From: Judith Ward
Sent: 10 December 2020 15:19
To: Linda Griffiths
Subject: 20/01162/DISC OS Parcel 7400 adj and south of Saltway

Judith Ward
Landscape Planning Officer
Cherwell District & South Northants Councils

TITLE
CUT AND FILL ANALYSIS - SPORTS PITCH B SECTIONS

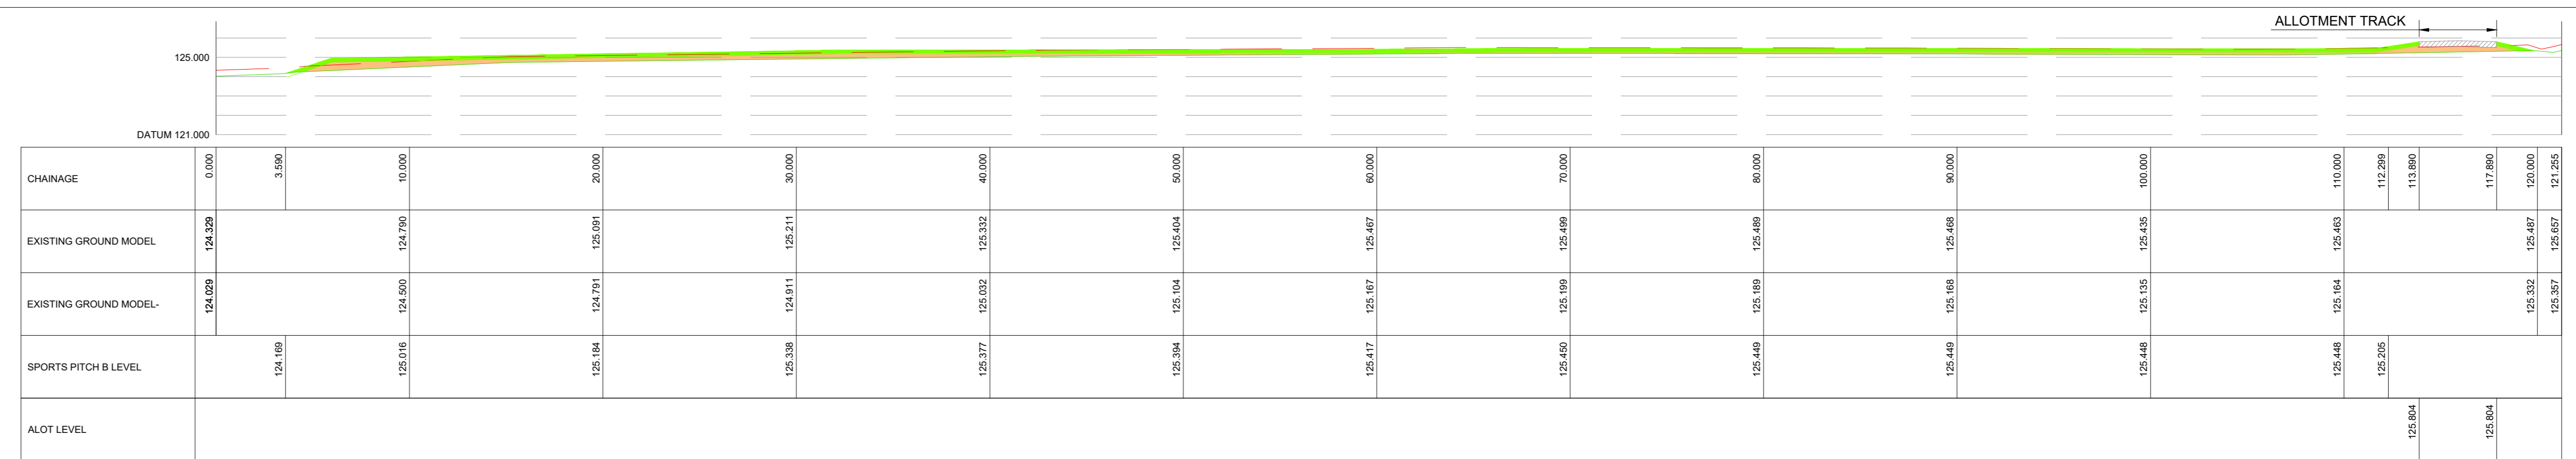
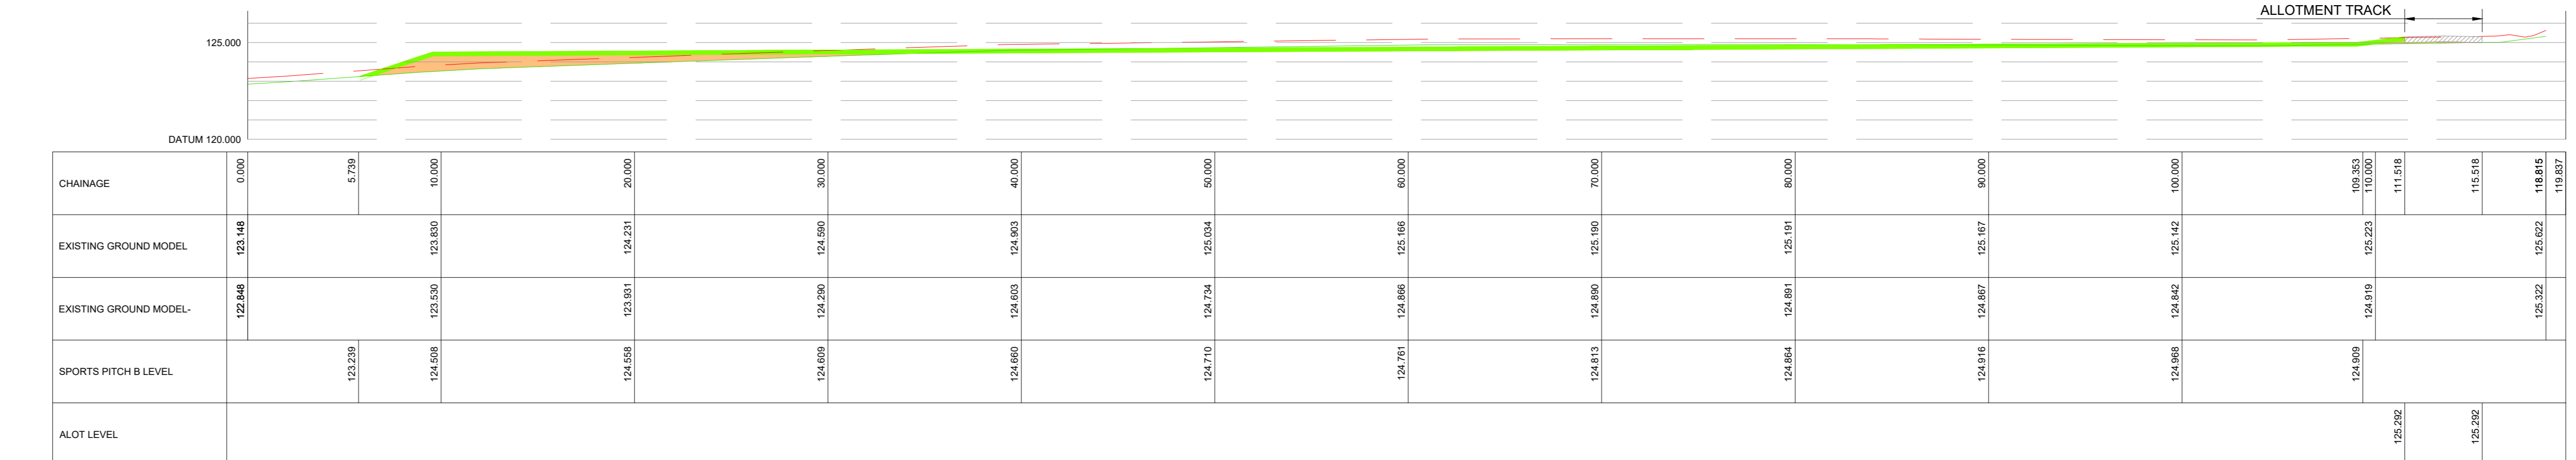
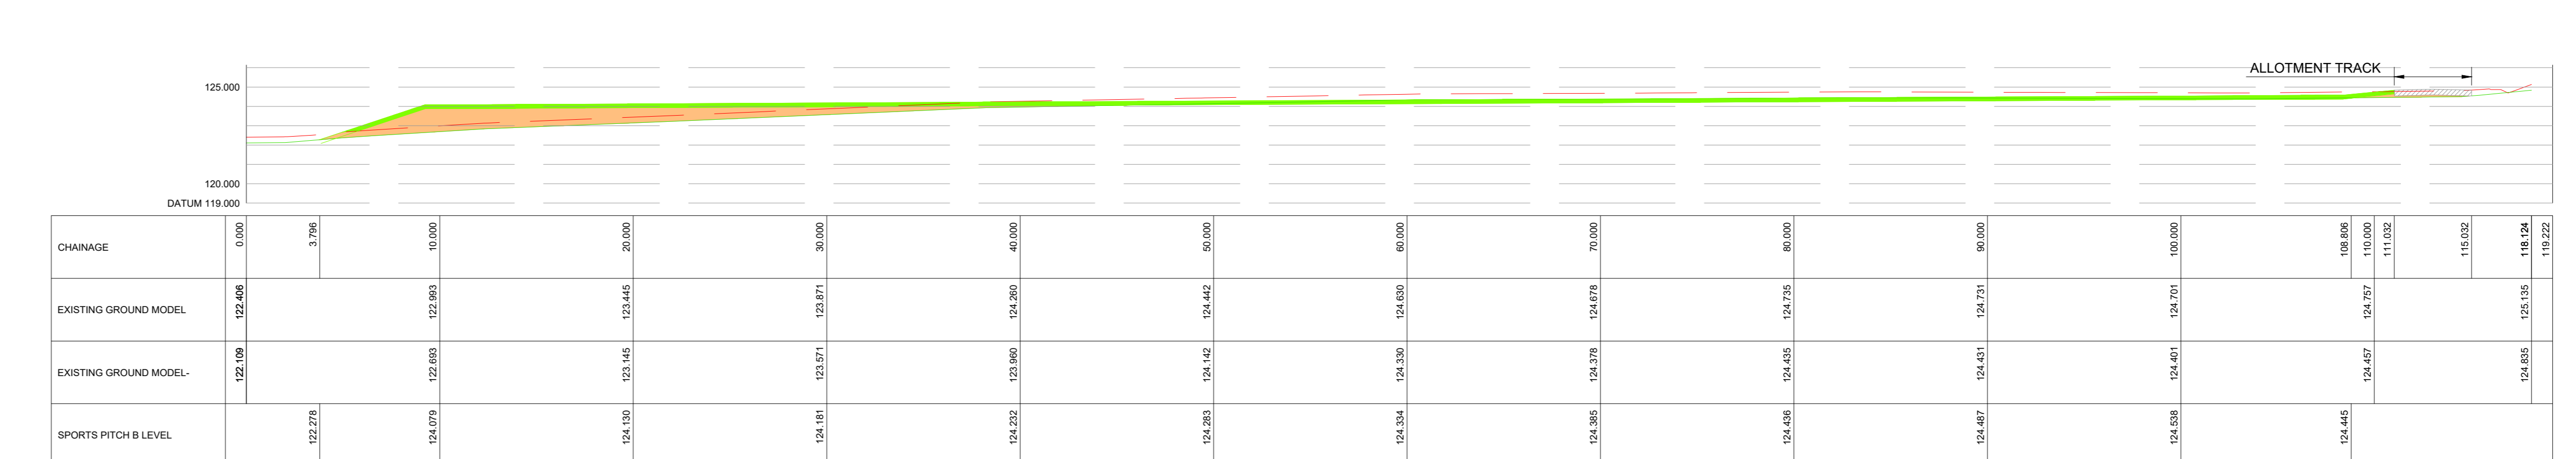
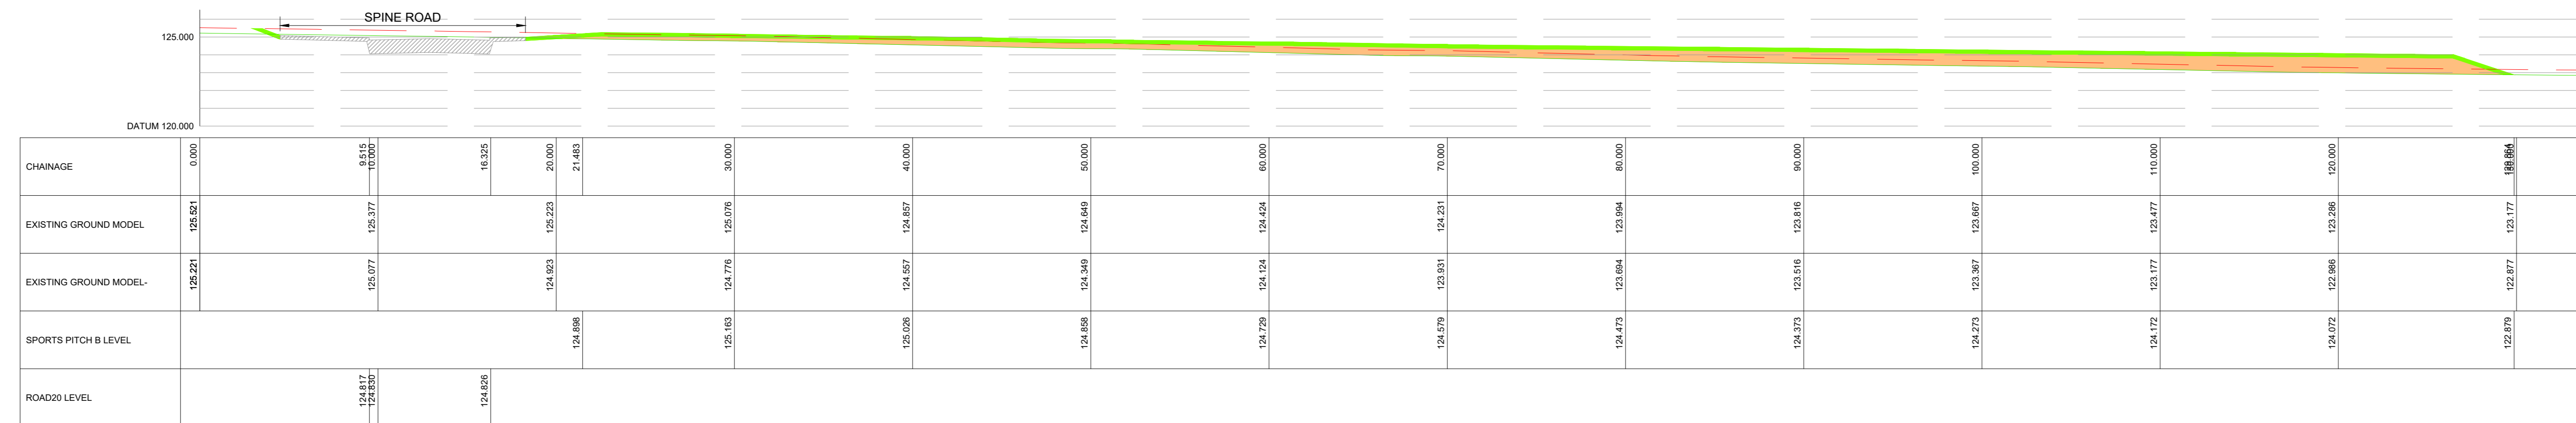
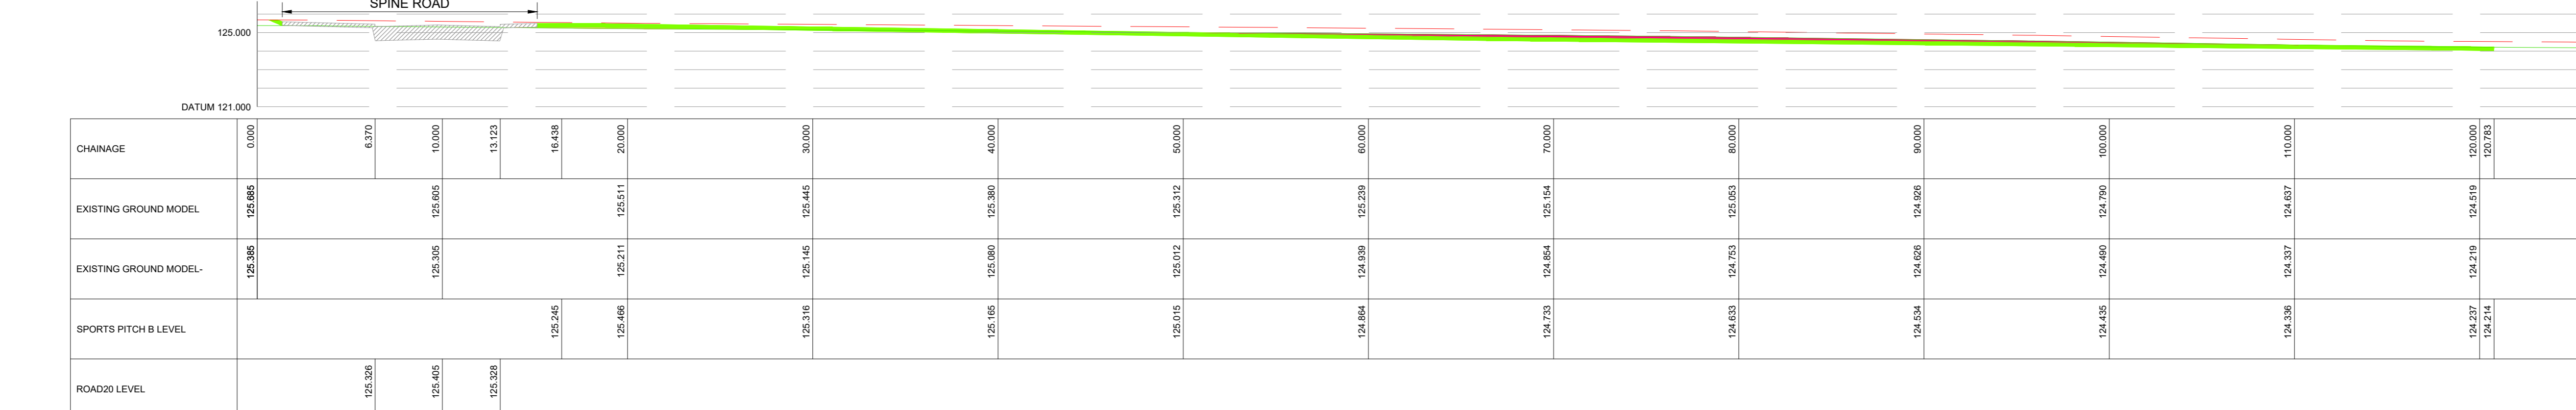
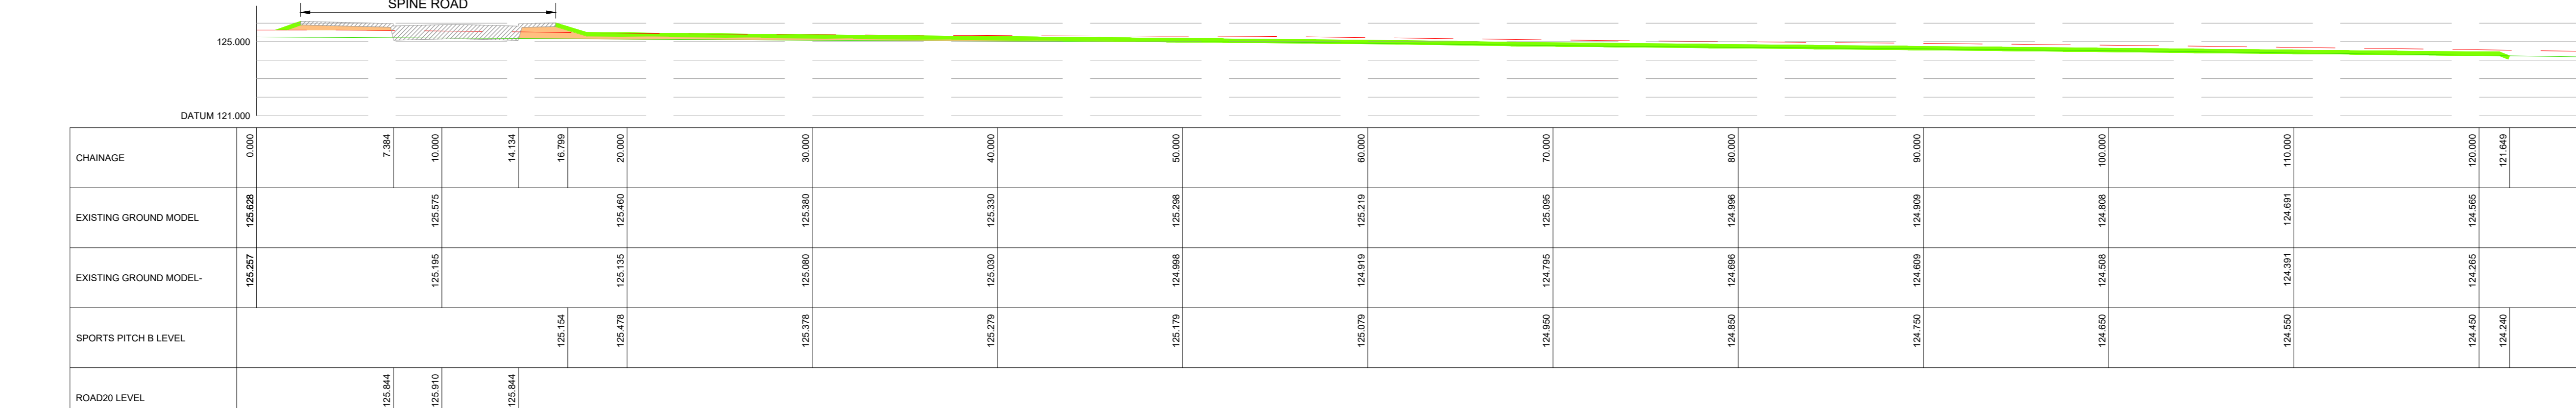
The slope to the East side of football pitch is quite steep. I would prefer it to be to a shallower gradient so that it looks more natural.
